GRADING AND EROSION CONTROL PLAN
SOUTH ACADEMY BUSINESS CENTER
EL PASO COUNTY, COLORADO

SOUTH ACADEMY BUSINESS CENTER

DRAINAGE, GRADING & EROSION CONTROL COVER

2 of 5

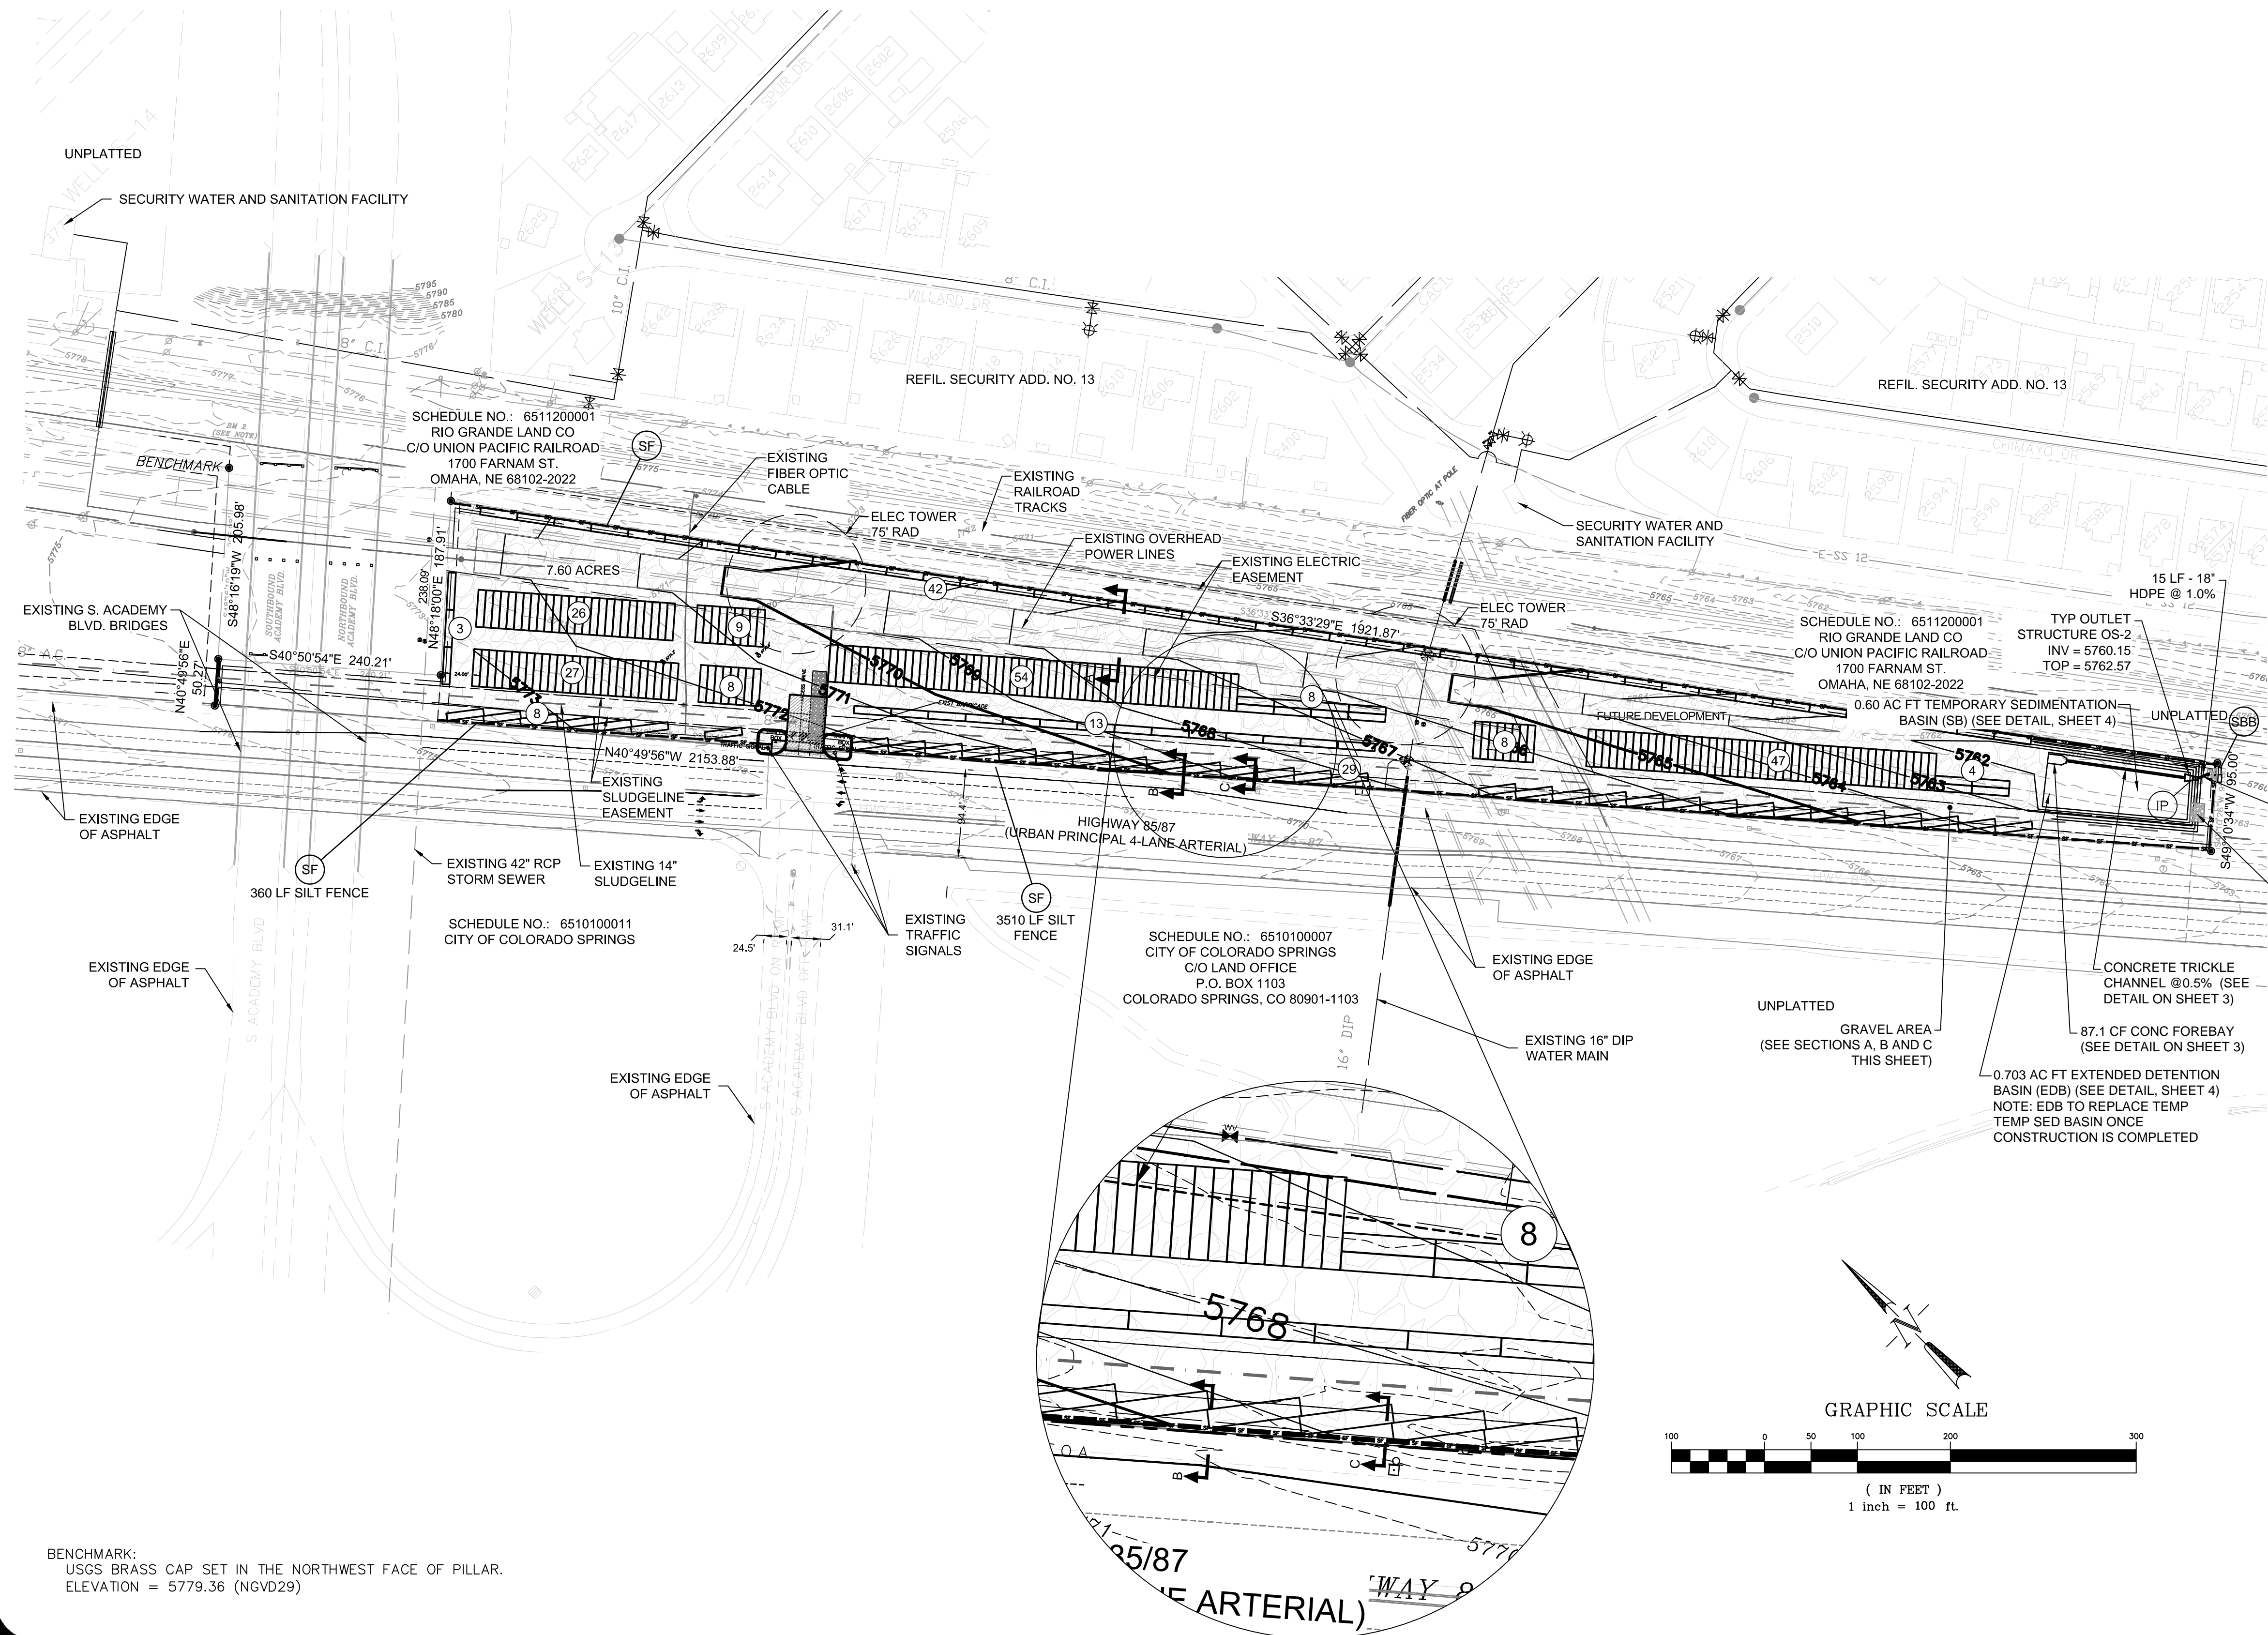
Based on the Construction Timing on the SWMP a Temporary Sediment Basin is required. Include the detail.
Note the required volume and riser pipe configuration.

CONCRETE FOREBAY DETAIL  
NOT TO SCALE

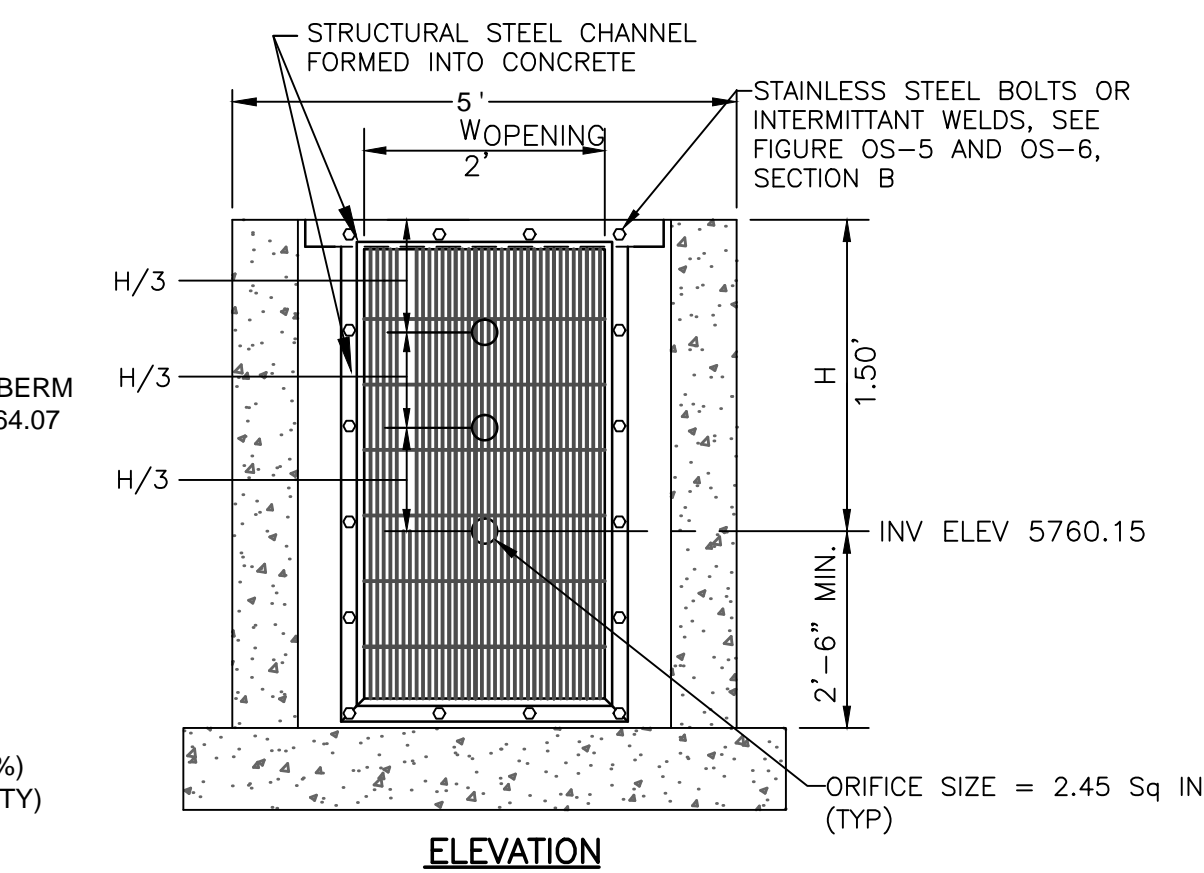
Previous submittal had a forebay section detail. Reinsert to show the relationship b/w the forebay and trickle channel. Alternatively, grade tags may be able to identify how these to connect/relate to each other. **Unresolved. There are no construction detail for how this relates vertically relative to the rest of the pond.**

EMERGENCY SPILLWAY DETAIL  
SEC A-A  
NOT TO SCALE

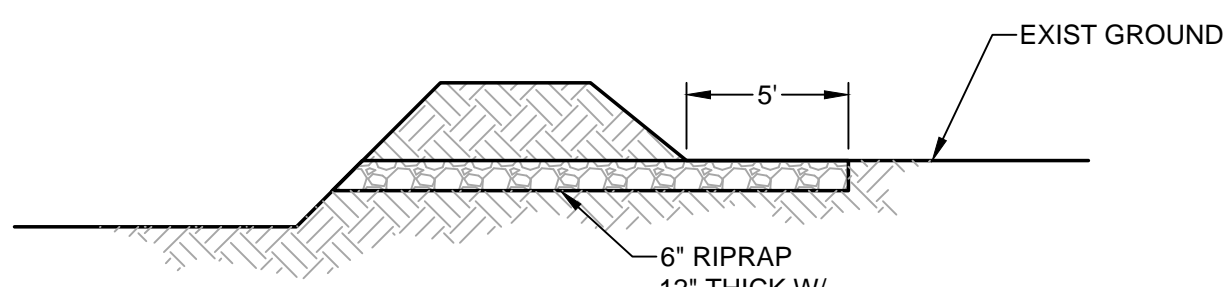
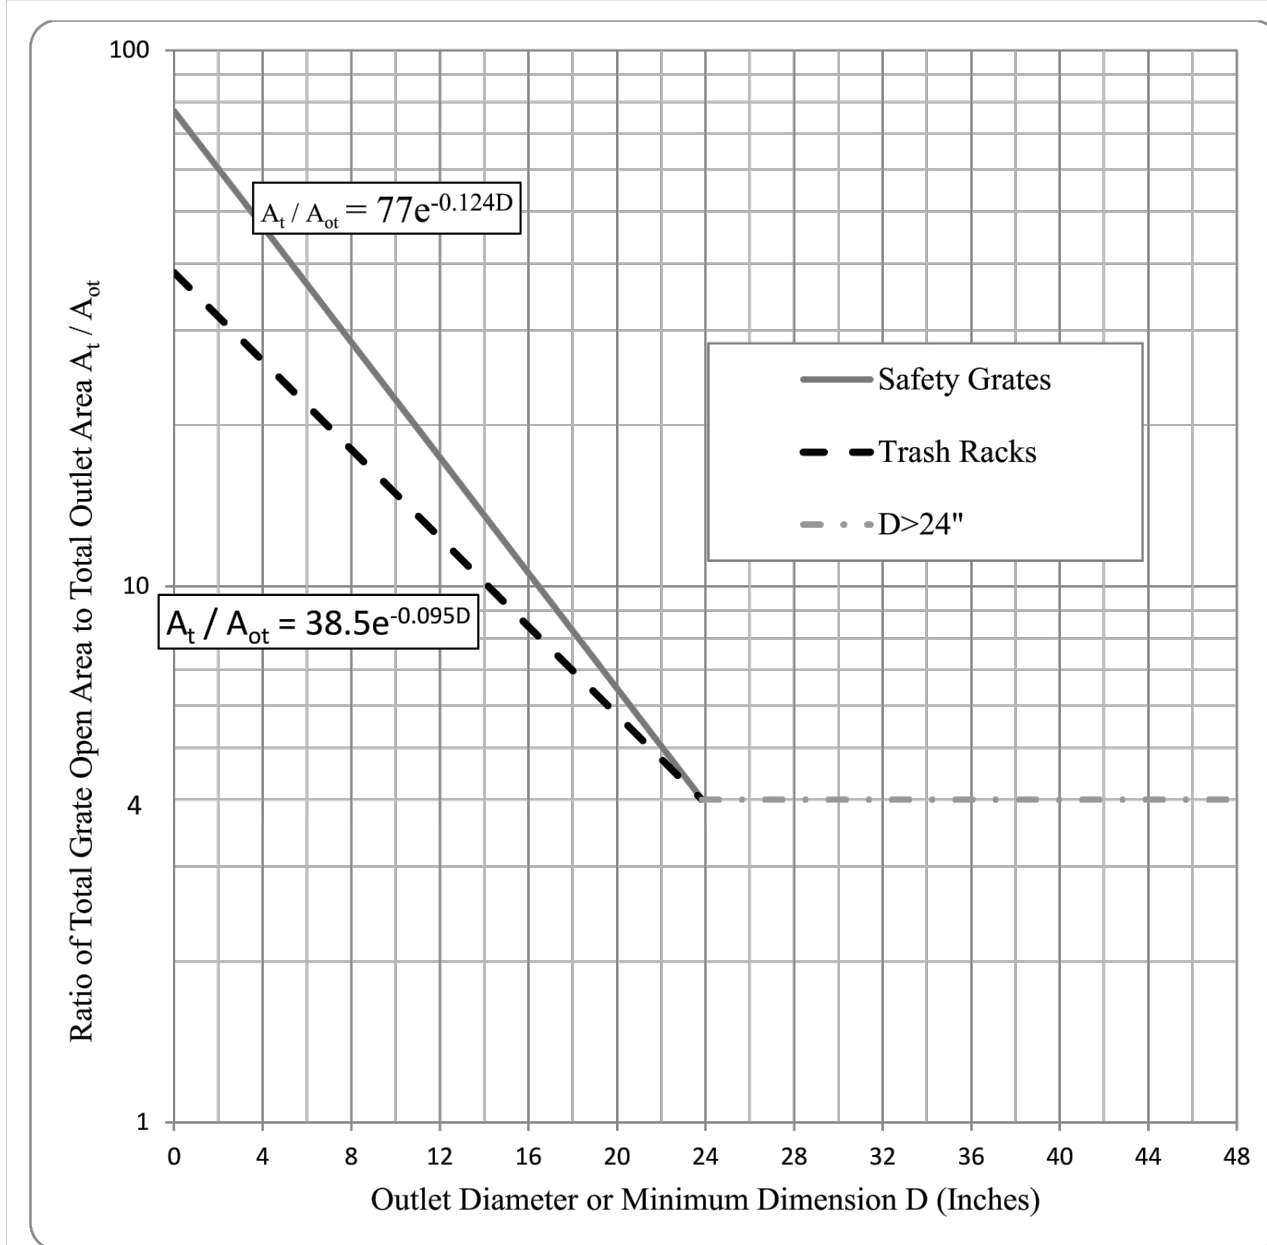
Per DCM Chapter 11, recommendations for embankment construction is required as part of the geotechnical report. Incorporate the recommendation in the construction details. **Unresolved.**

This does not match. **Unresolved. How can an outlet pipe and spillway crest both be at existing ground?**

Figure OS-1. Trash Rack Sizing

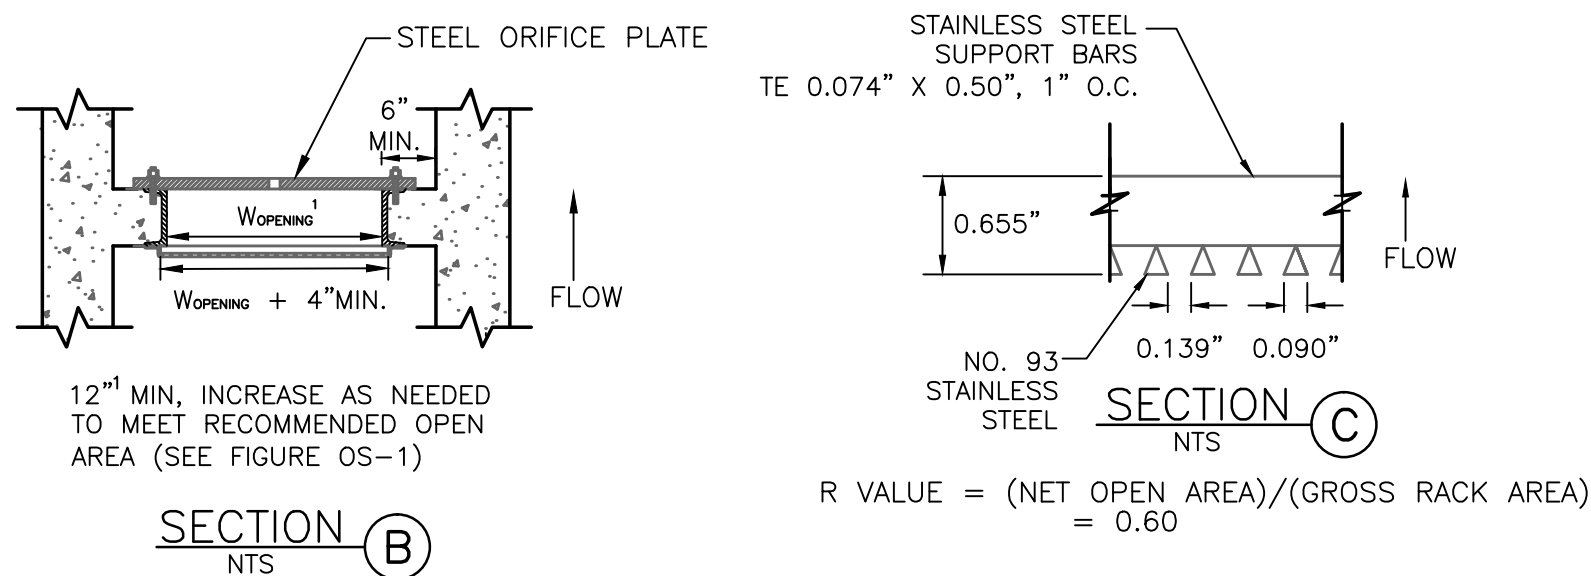
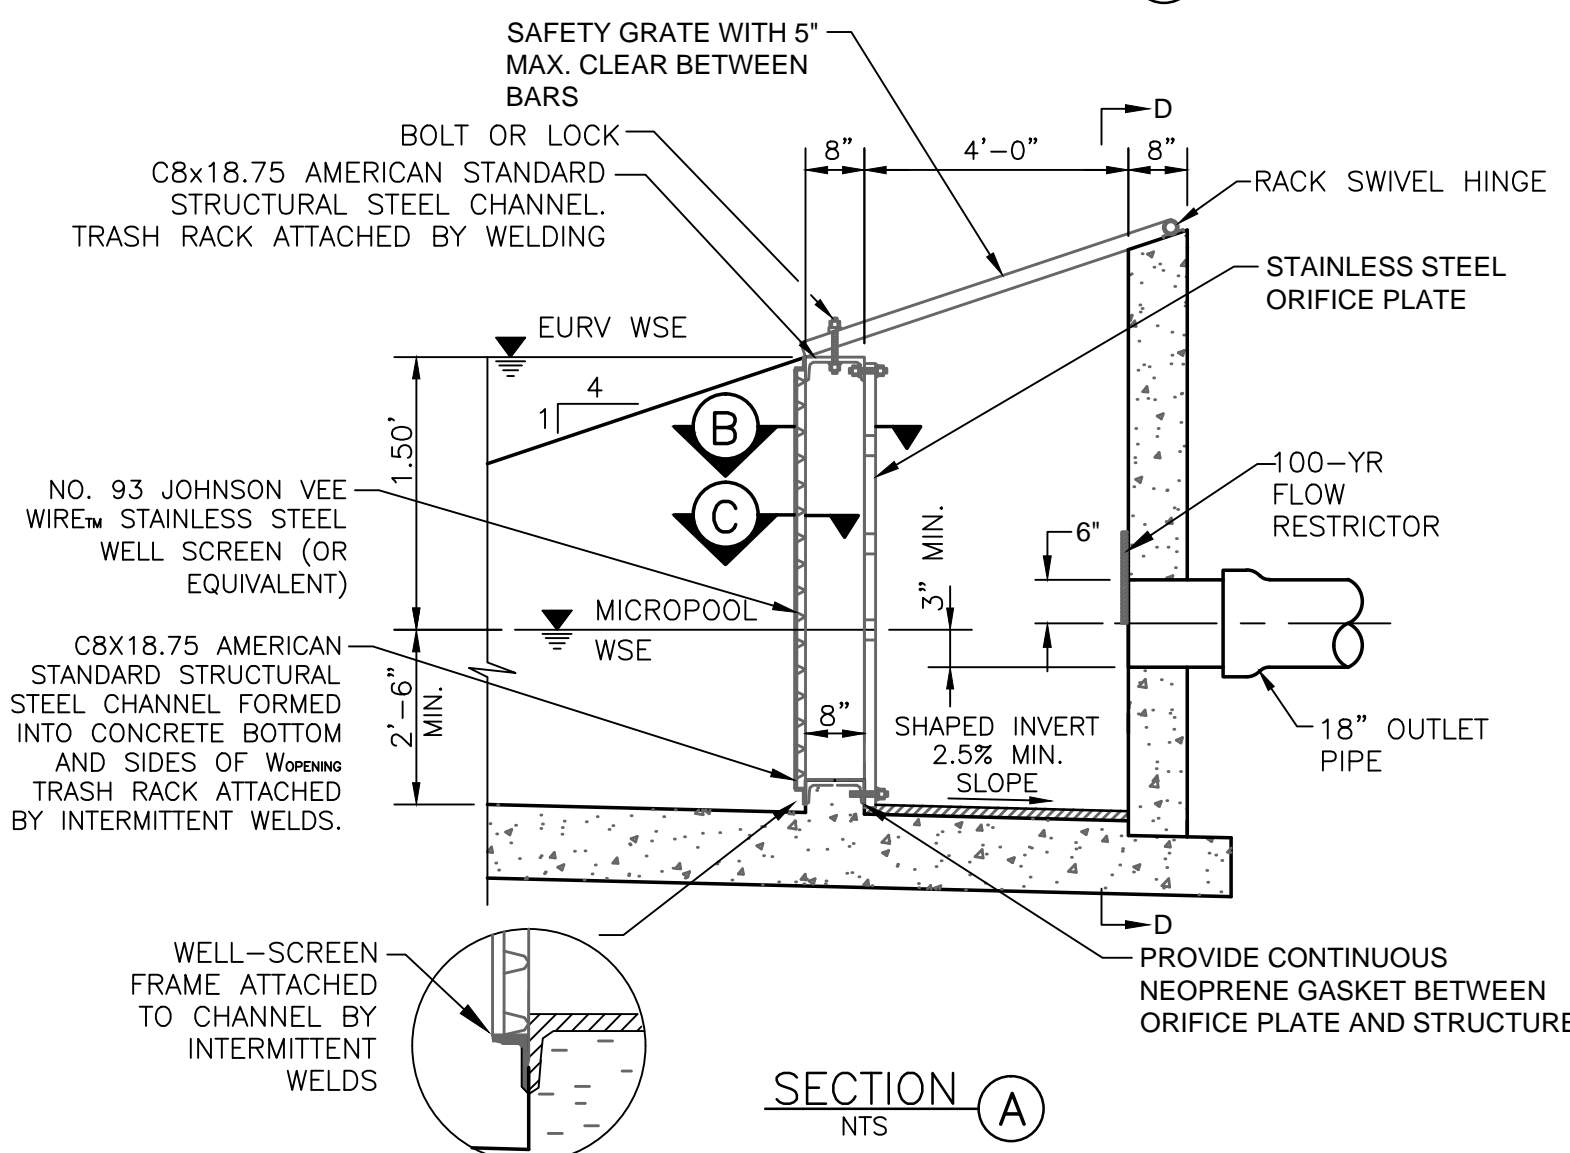
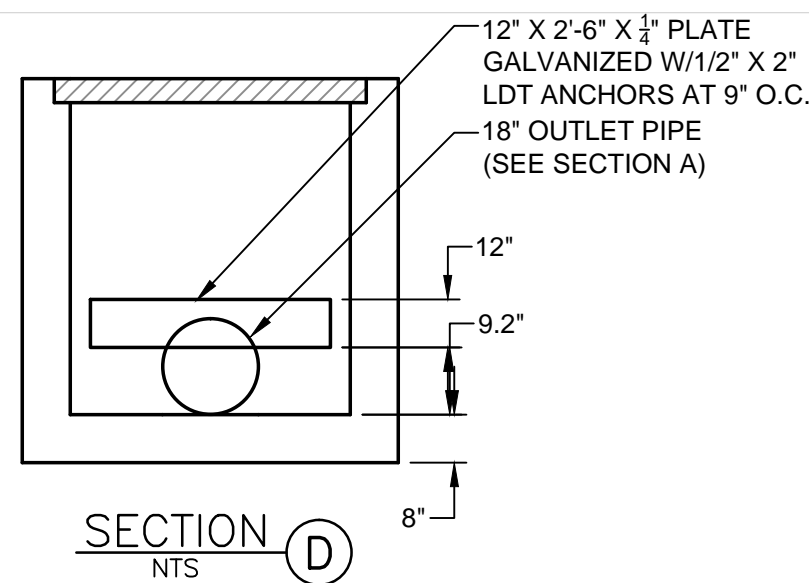
Revise to identify the actual plate thickness needed.

Identify the thickness, the material (stainless steel or something else?), and how it's attached (bolted and at what spacing?).

Unresolved. Based on the FDR design this should be a 6\"/>

SF-1. SILT FENCE

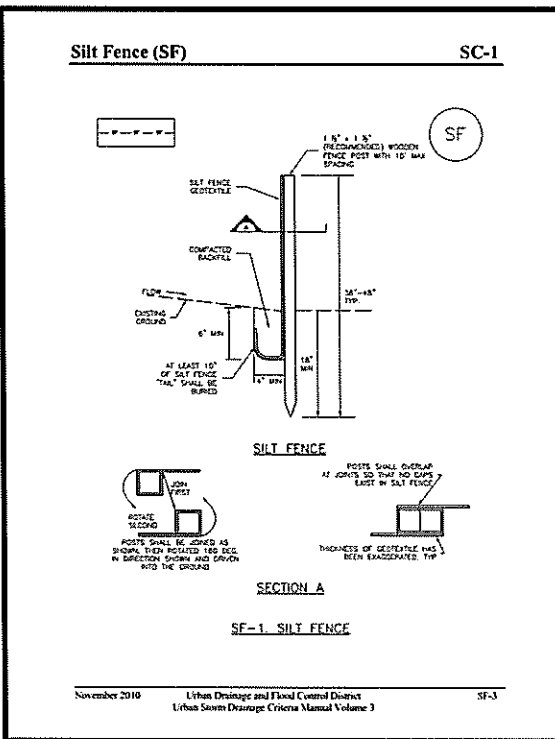
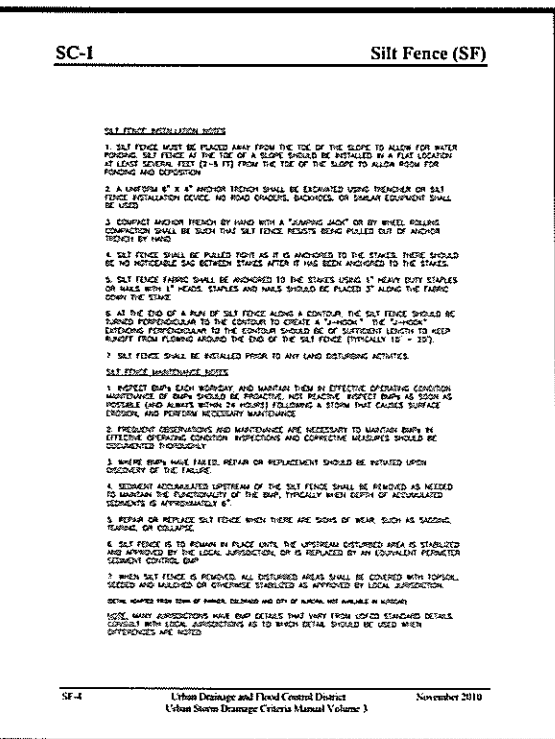
Add the silt fence detail. Unresolved.
